From: Nicola Spencer on behalf of Planning.Responses
Sent: 19 December 2025 11:10
To: Planning Scanning
Subject: FW: R/215/25/HH

The extension overshadows or overlooks a J WOODS 1 EVELYN AVE ,key windows TO MAIN LIVING AREA AS HEIGHT IS TO CLOSE

Scales: **1:100** No: **3434/01/02**

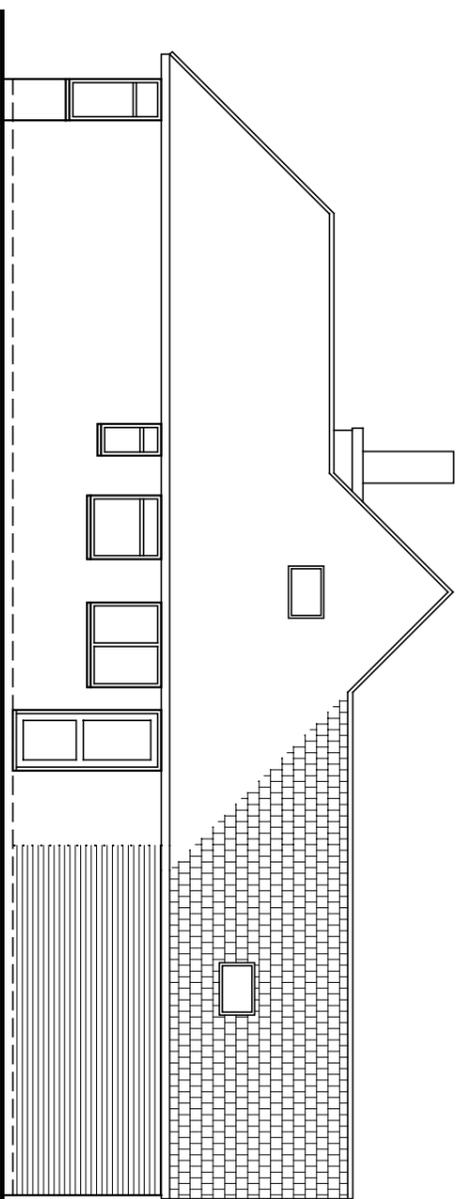
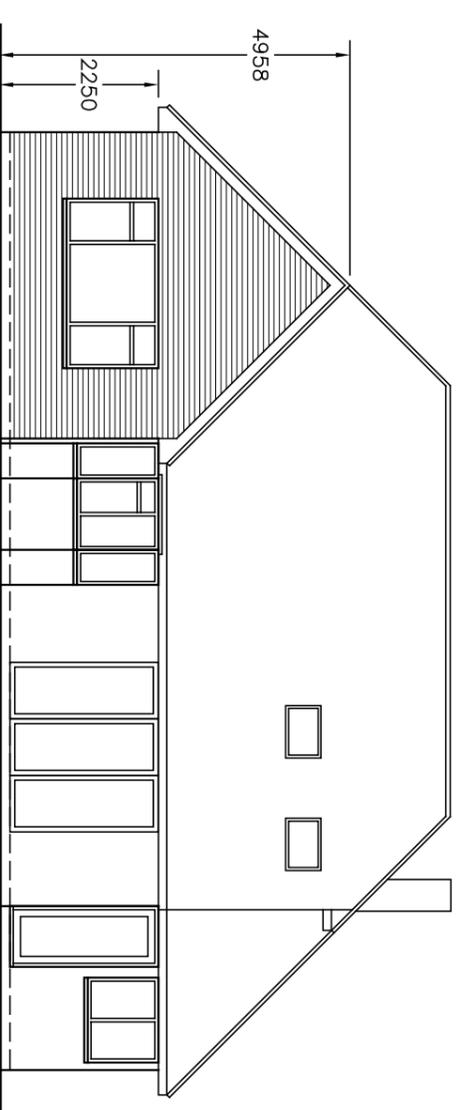
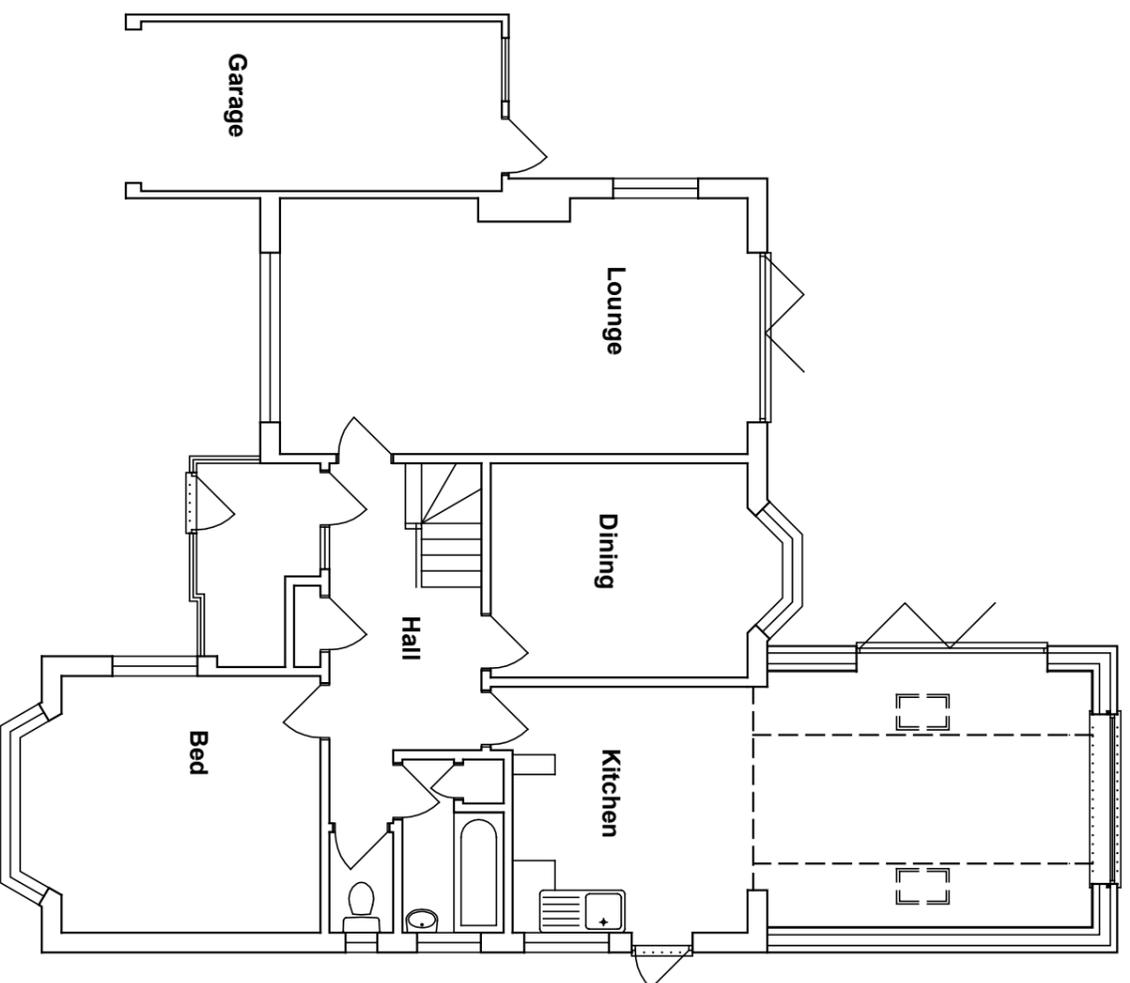
"BLOCK PLANS SHOWS CLEARLY"
EXTENSION , WOULD APPEAR AS" BRICK WALL AND GUTTER" VIEWABLE INTRUSIVE AND UNSIGHTLY

Proposed plans will leave "21 ft of brick wall and gutter", running along my south border view, in my direct view from my home, my south border outlook would be unsightly over shadowing overbearing, intrusive unsightly

planned extension will block sunlight to main living area and also conservatory, my south border where light comes from is where thompsons plan to build, wall and gutter will be high enough to make this occur
